# **Proposed Extension of Chatswood Chase Shopping Centre**

## **Response to Traffic Matters Raised in Willoughby Council's Letter of 12 August**

Revisions	No.	Description	Date
A	1	For Planning	20/06/2006
B	2	For Planning	13/07/2006
C	3	Garlanded Revisions	28/03/2007
D	4	Seats & Bike Hoops Added	21/04/2007
E	5	Garlanded Revisions	21/09/2007

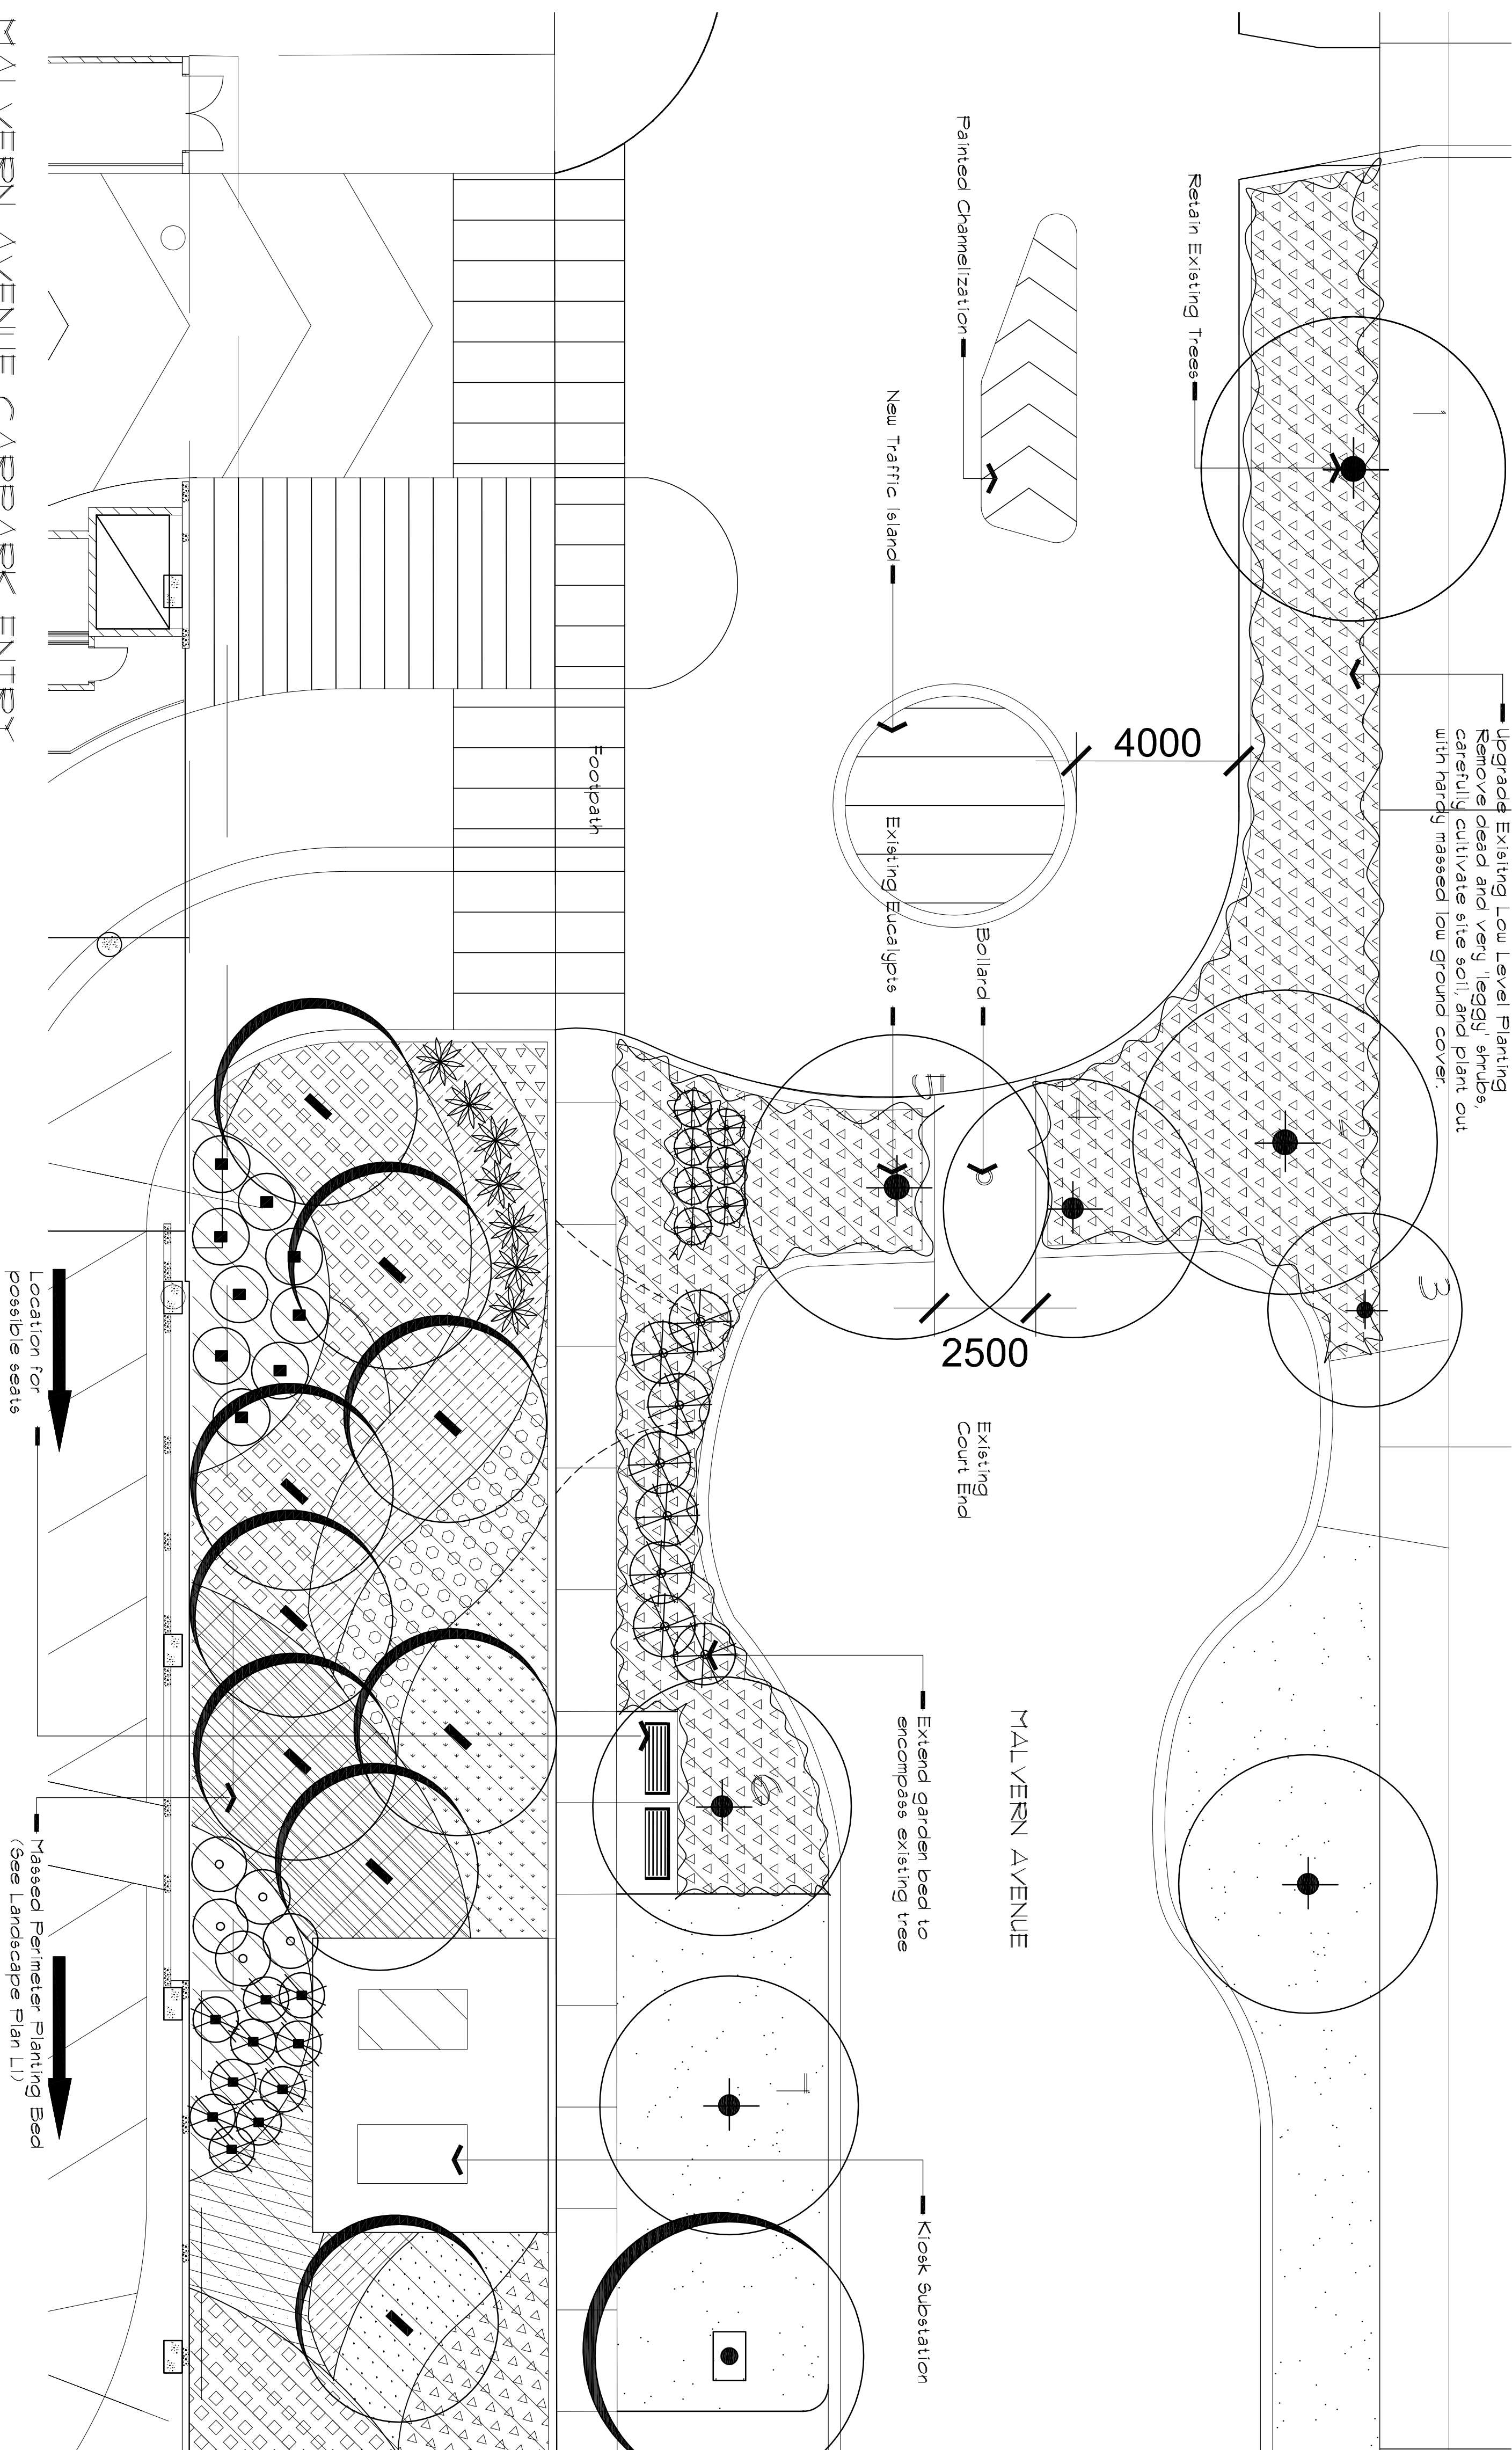
**Item m) Redesign of Malvern Avenue driveways**

The design has been modified to separate the driveways as suggested by Council. The potential for improved delineation of movements in Malvern Avenue is being investigated in conjunction with landscaping plans.
